69 Northaw Rd
East

Sent: 09 November 2010 00:18
To: Planning
Subject: Welwyn Hatfield Council Online Planning - Comment

Application Number: S6/2010/2260/FP

Drawing N°: ELA/6 Rev: 01

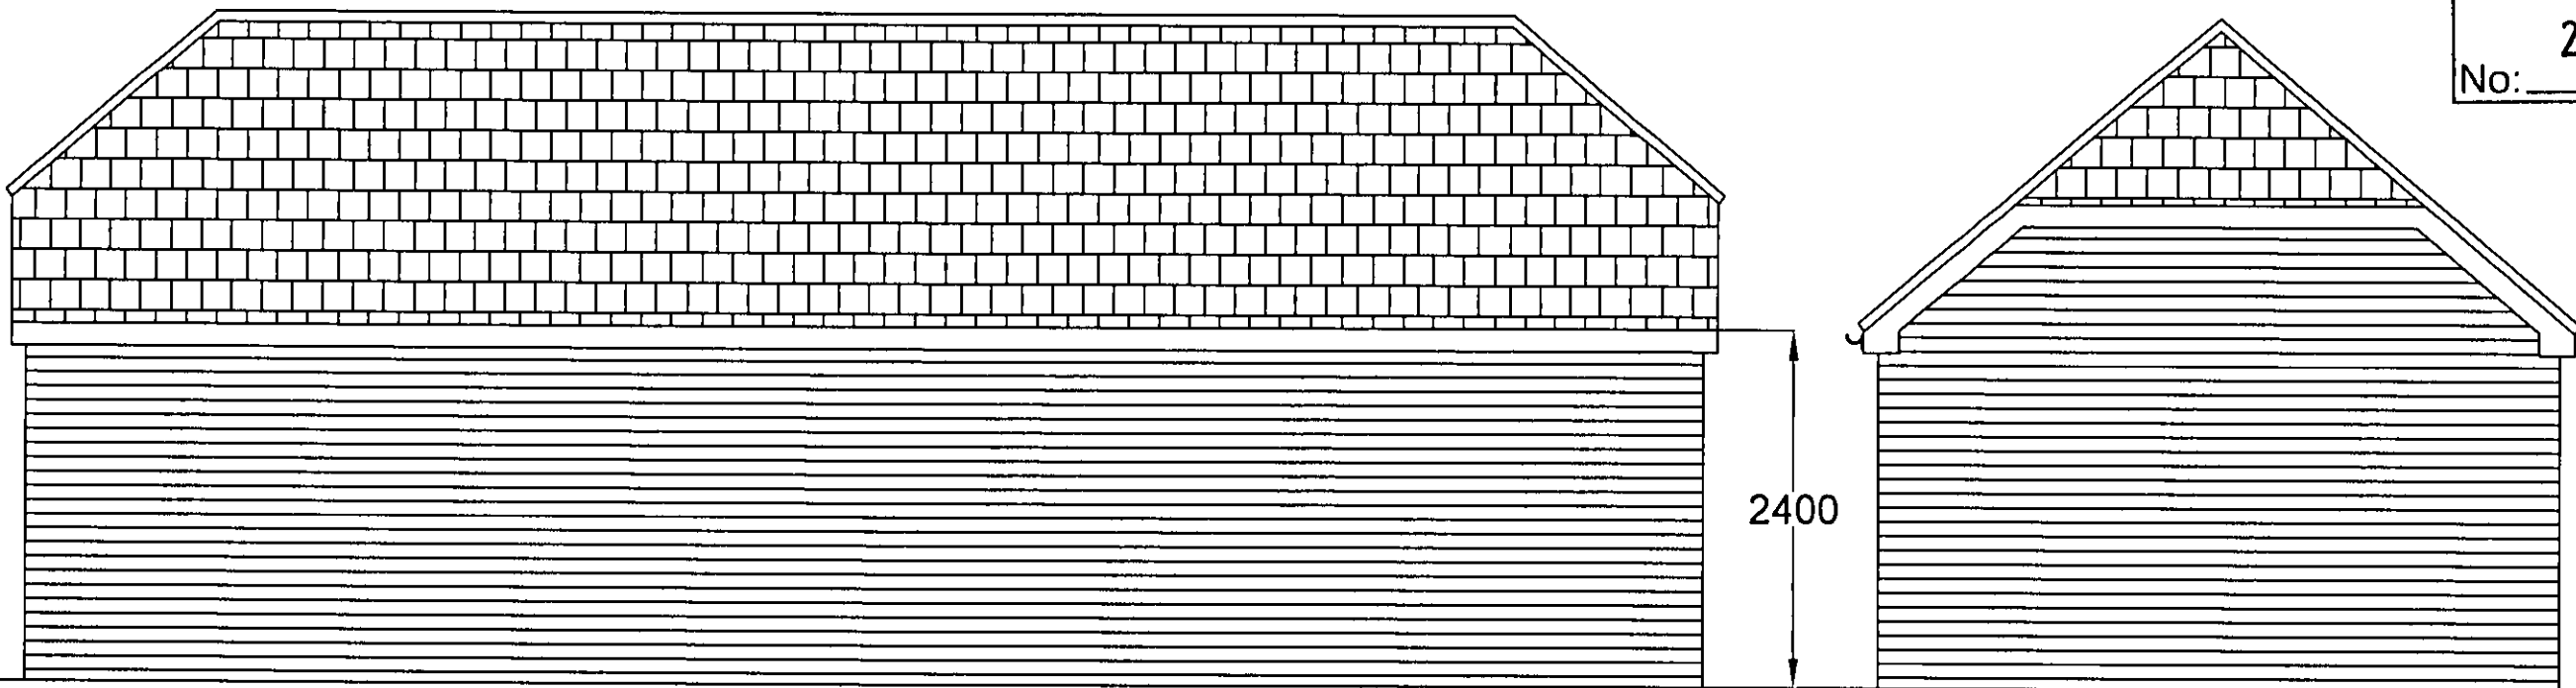
Comment: Permission has already been granted (surprisingly) for this 'Out Building' to be 4m tall - for a Gym & Sunroom!!!

Now the new application wants to increase the height even further - why?
